08 October 2024

**REVISED INFORMATION PACK
LAND AT PENISTONE ROAD / ROWLEY LANE, FENAY BRIDGE**

I am writing in response to your email of 5th April 2024, and our subsequent meeting of 11th April 2024 to discuss consultee concerns with the Reserved Matters submission for 67 dwellings at Penistone Road / Rowley Lane, Fenay Bridge (2024/90058). This letter provides clarification or additional information in response to those comments in order to help resolve the matters raised and assist the decision-making process. The response is provided across a series of topic specific pages appended to this letter, comments made by the Council are paraphrased for ease of reference.

| JM  | MH  | MAR'23 | 1/500 @A1 | E23/8060/001E |

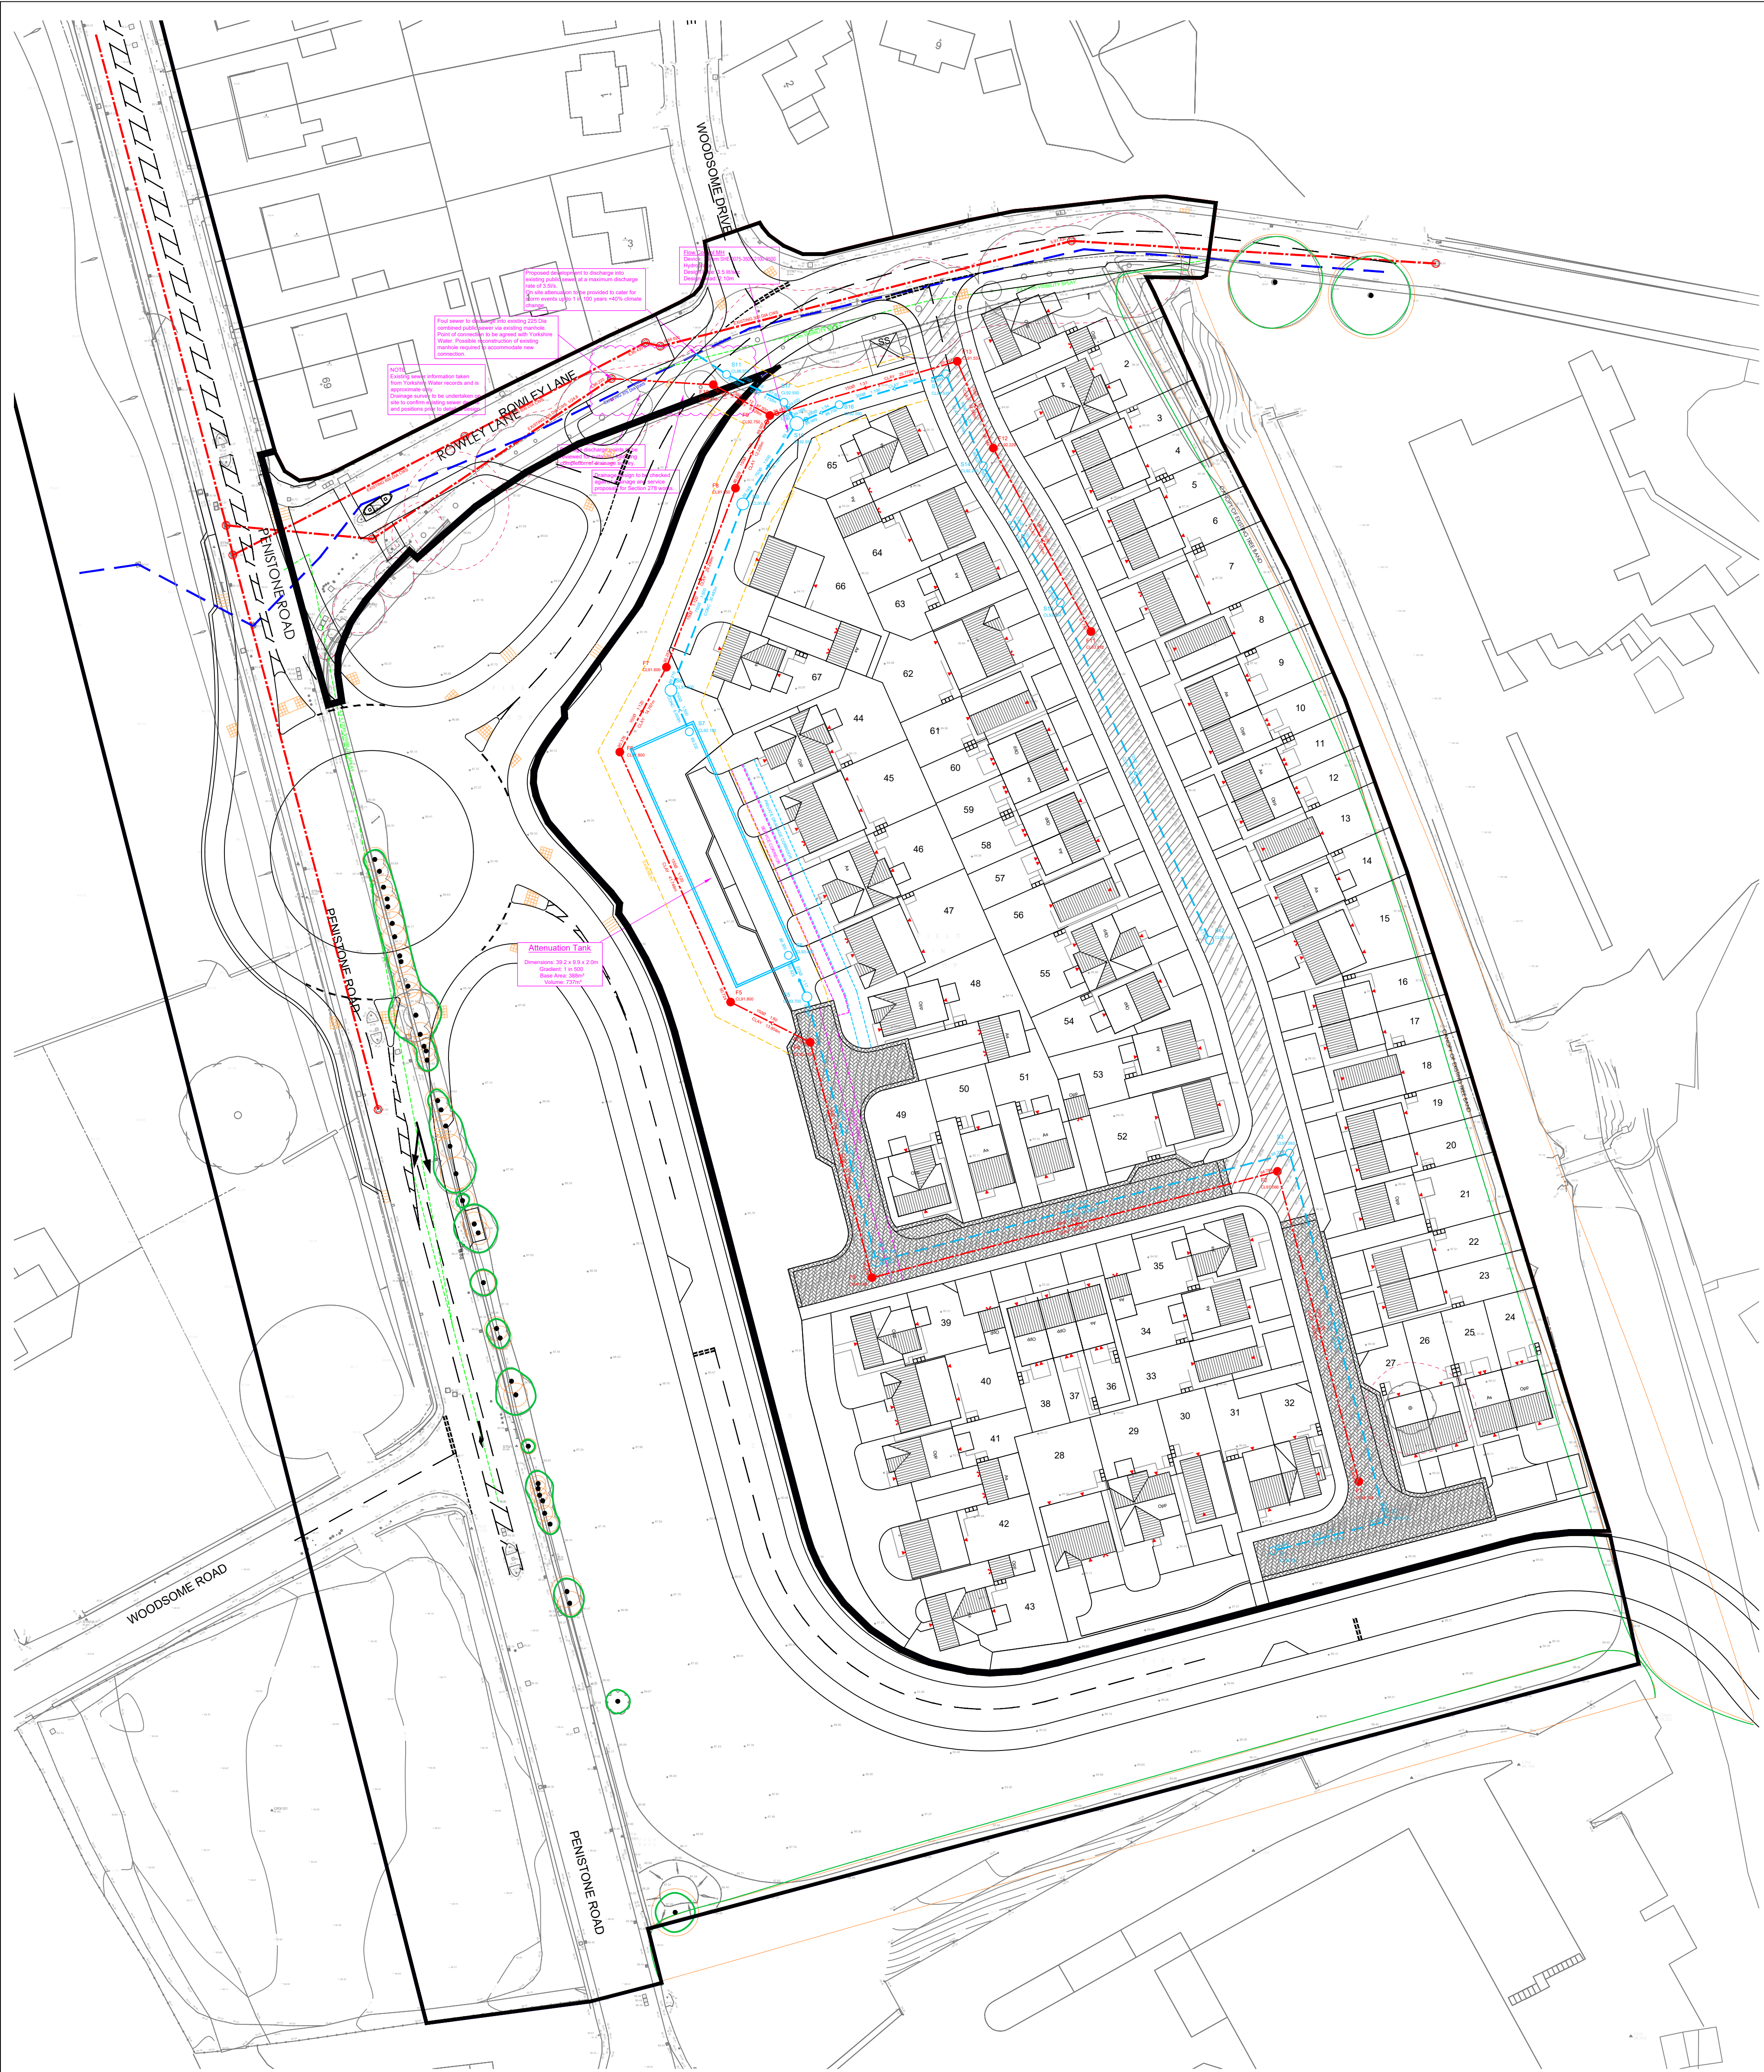
- 1) Condition 7 – WYAAS response remains outstanding.
- 2) Condition 8 – LLFA objection as management cannot be done by the developer. There is a requirement to demonstrate how the future development can be attenuated by the proposed tank.

- 10) Conditions 27, 28 & 29 – 2024/44/90750 – Discussions ongoing with S278 Team and Highways team regarding Rowley Lane and Penistone Road Improvements.

- 1) Please can the updated WYAAS response be provided.
- 2) Updated Engineering Feasibility Plan is provided.
- 3) No action required.
- 4) Updated Landscape Plan is provided detailing replacement planting.

- 10) Updated drawings were issued on 10th September 2024 and we await the Council's comments on this. As the on-site detailed design works have not yet been progressed/agreed there are some outstanding items which are still to be addressed. The main one being the re-grading of the banking and/or retaining wall along the site boundary and how it will tie in with the S278 works.
